Our ref: NO/2012/104434/01-L01
Your ref: 3/2012/0669

Date: 02 November 2012

ERECTION OF INDUSTRIAL UNIT AND ALTERATIONS TO PARKING PROVISIONS LINCOLN WAY, CLITHEROE

PROPOSED PLANS, ELEVATIONS AND SITE PLAN

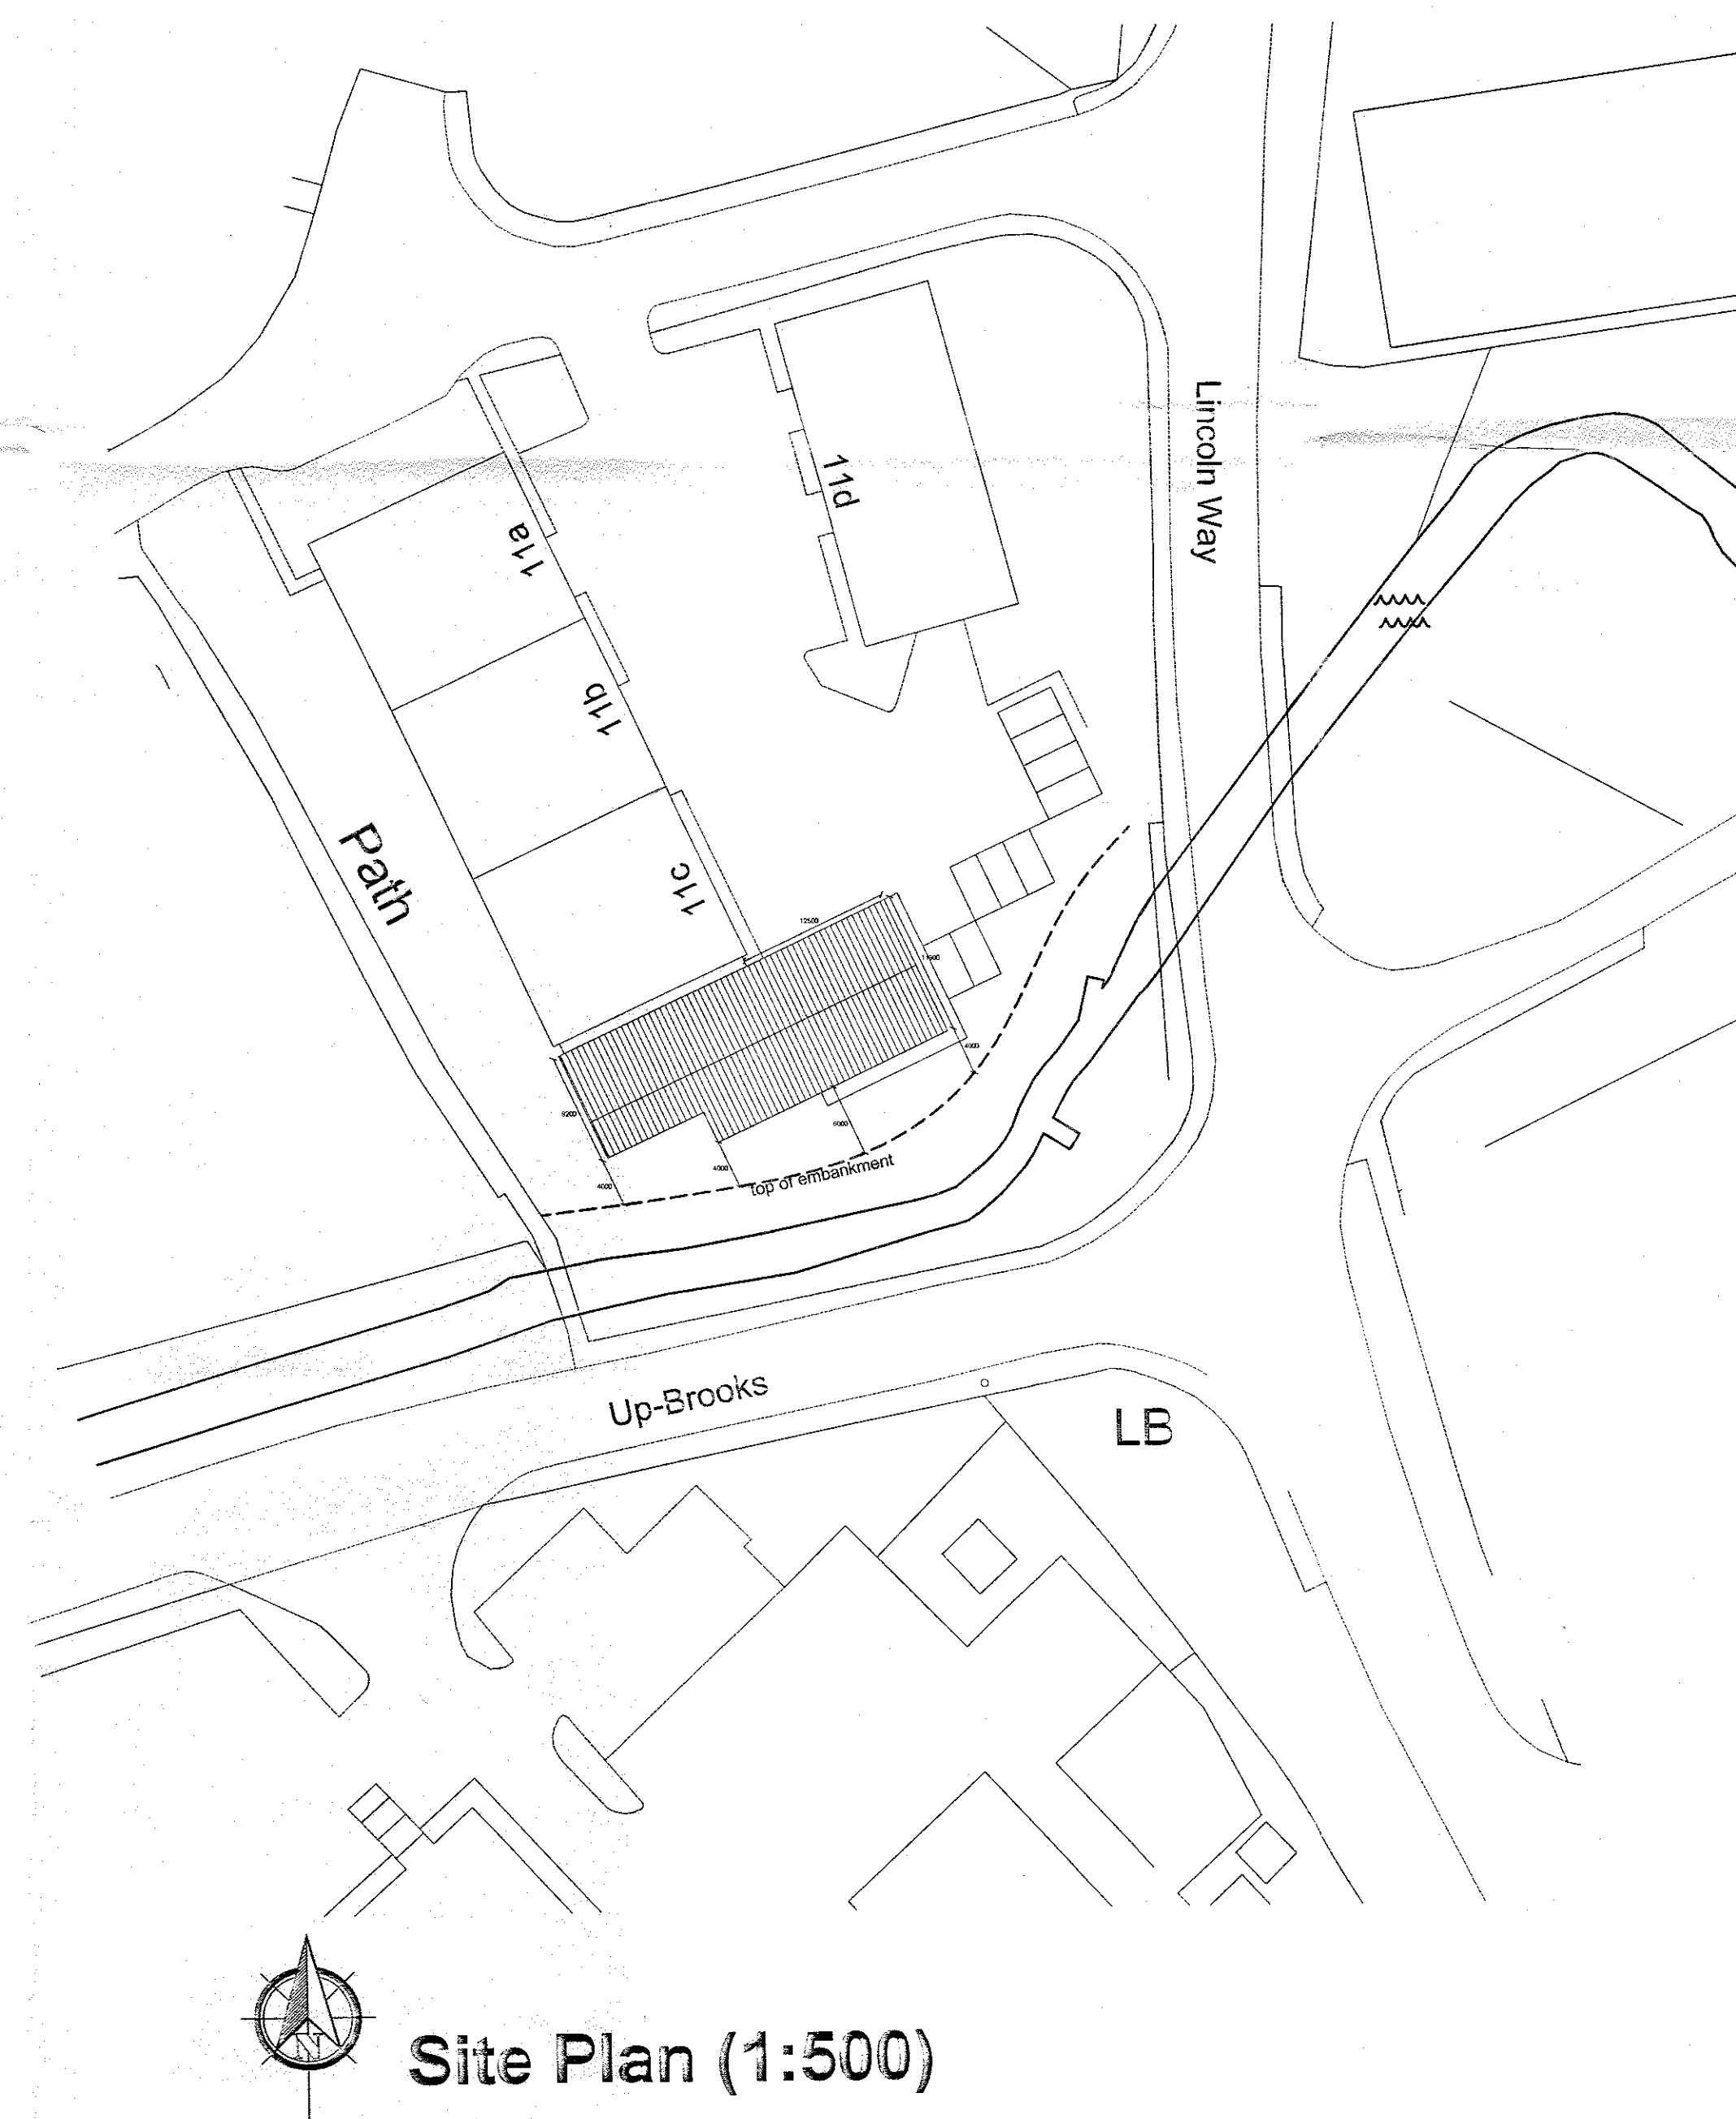
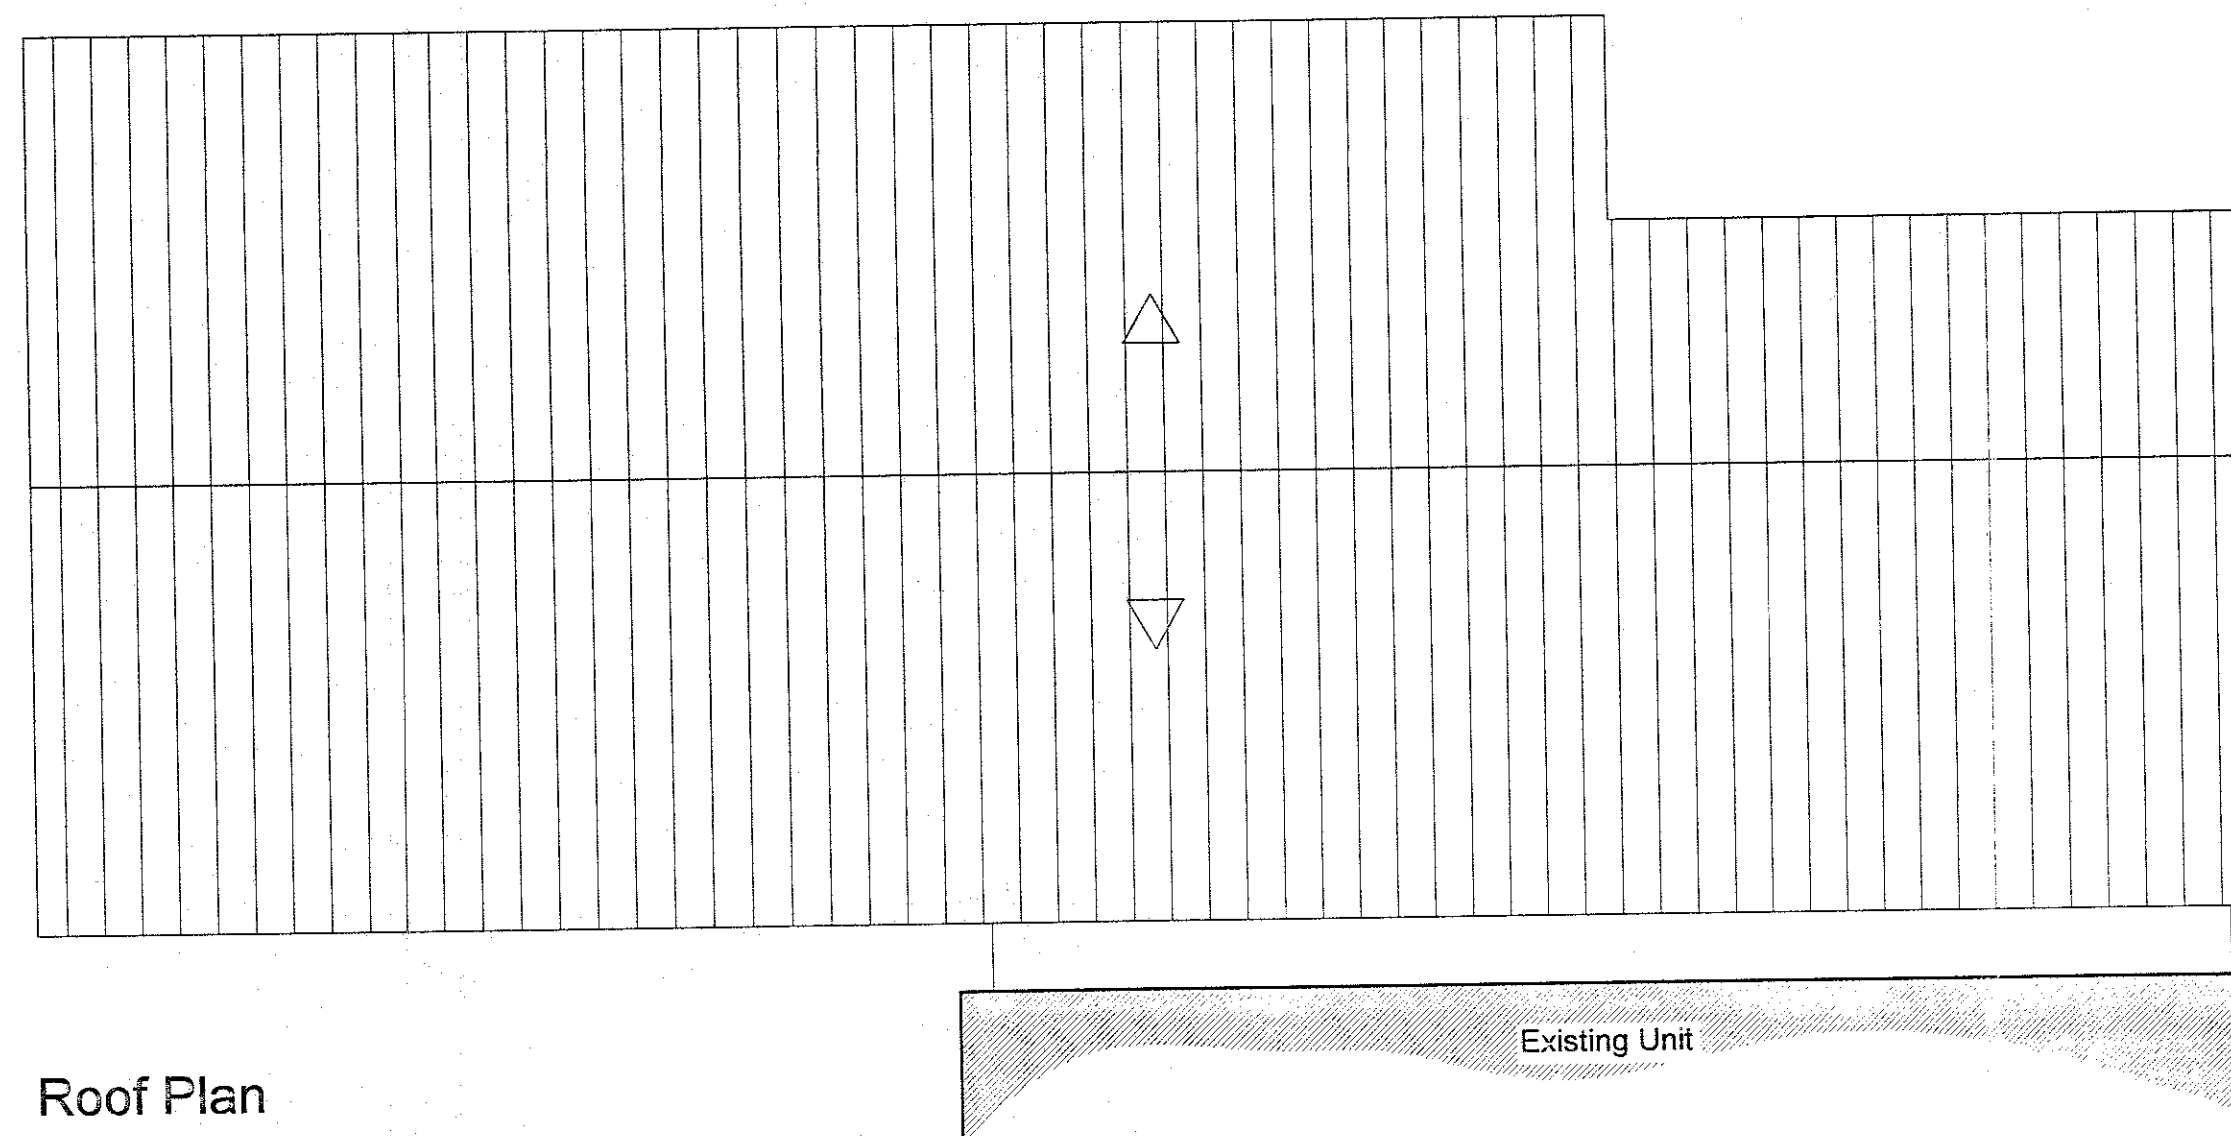
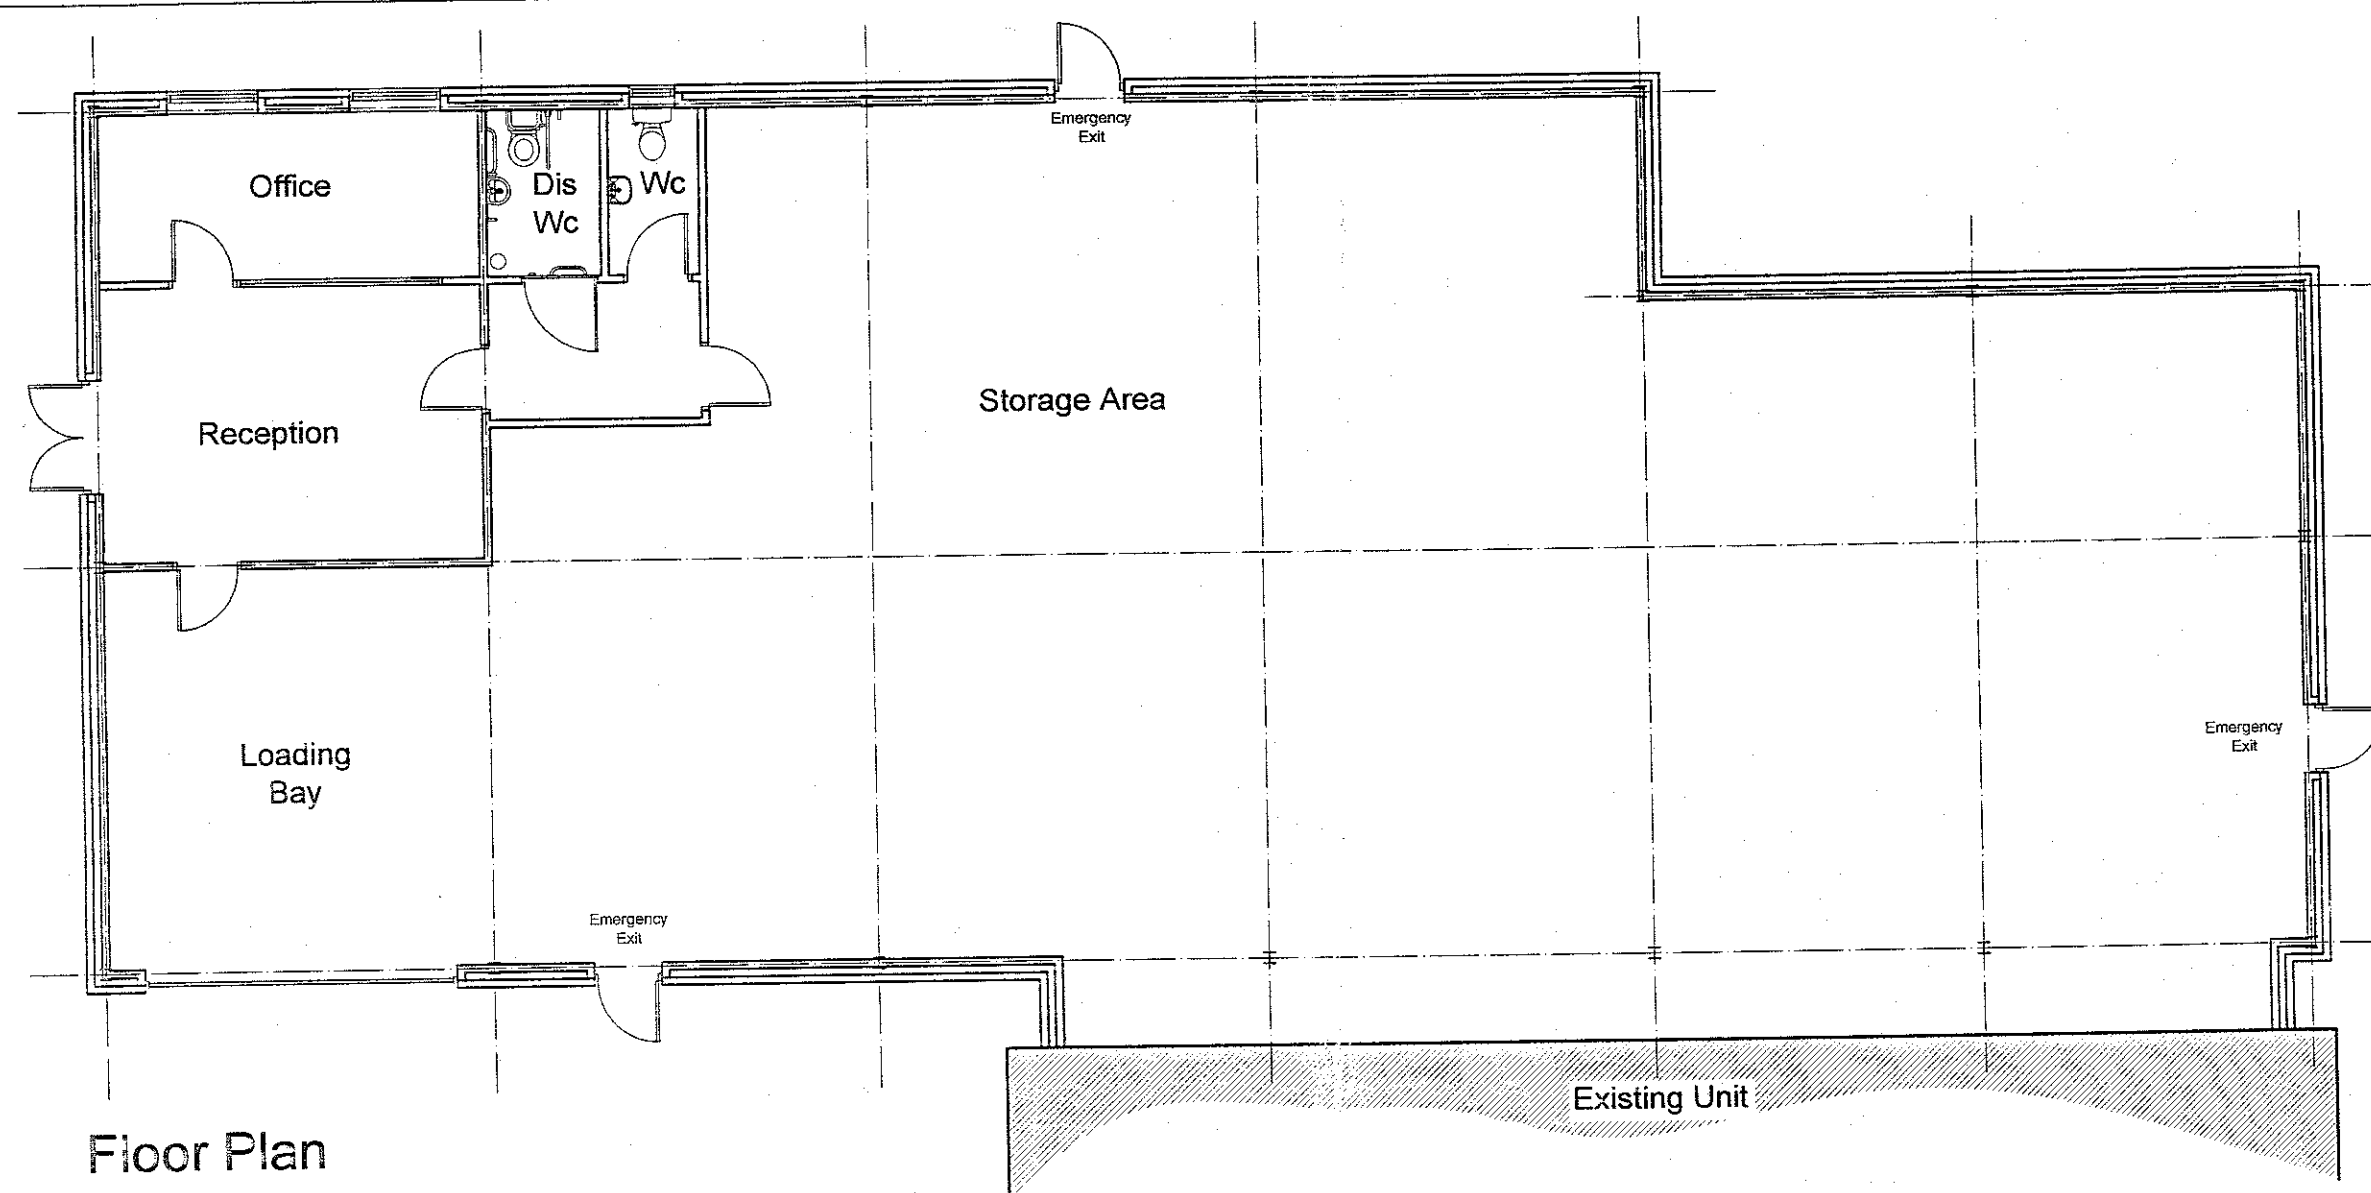
Mearley Brook is a designated Main River, Land Drainage Byelaws No.7 imposes restrictions to the effect that no trees or shrubs may be planted, fences, buildings, pipelines or any other structure erected within 8 metres of the top of the bank of the watercourse without the prior written Consent from the Environment Agency.

The Agency would be unlikely to give consent for the developments because it would unduly restrict essential maintenance and emergency access to the Main River watercourse. The permanent retention of a continuous unobstructed area is an essential requirement for future maintenance and improvement works to this river.

Additionally, our Biodiversity and Fisheries team have advised that building this close to the watercourse has the potential to negatively impact on the wildlife using the watercourse and embankments. A sufficient buffer zone must be maintained to ensure that wildlife habitats and water quality are not negatively impacted.

The scheme should be revised in order to maintain appropriate access arrangements and a suitable wildlife corridor next to the watercourse. The revised scheme should not significantly encroach within 8 meters of the top of the river bank.

We recommend that the applicant contact us to discuss our access requirements and provide revised cross-sectional plans and drawings showing the top of the riverbank and detail how the revised scheme will incorporate these requirements.
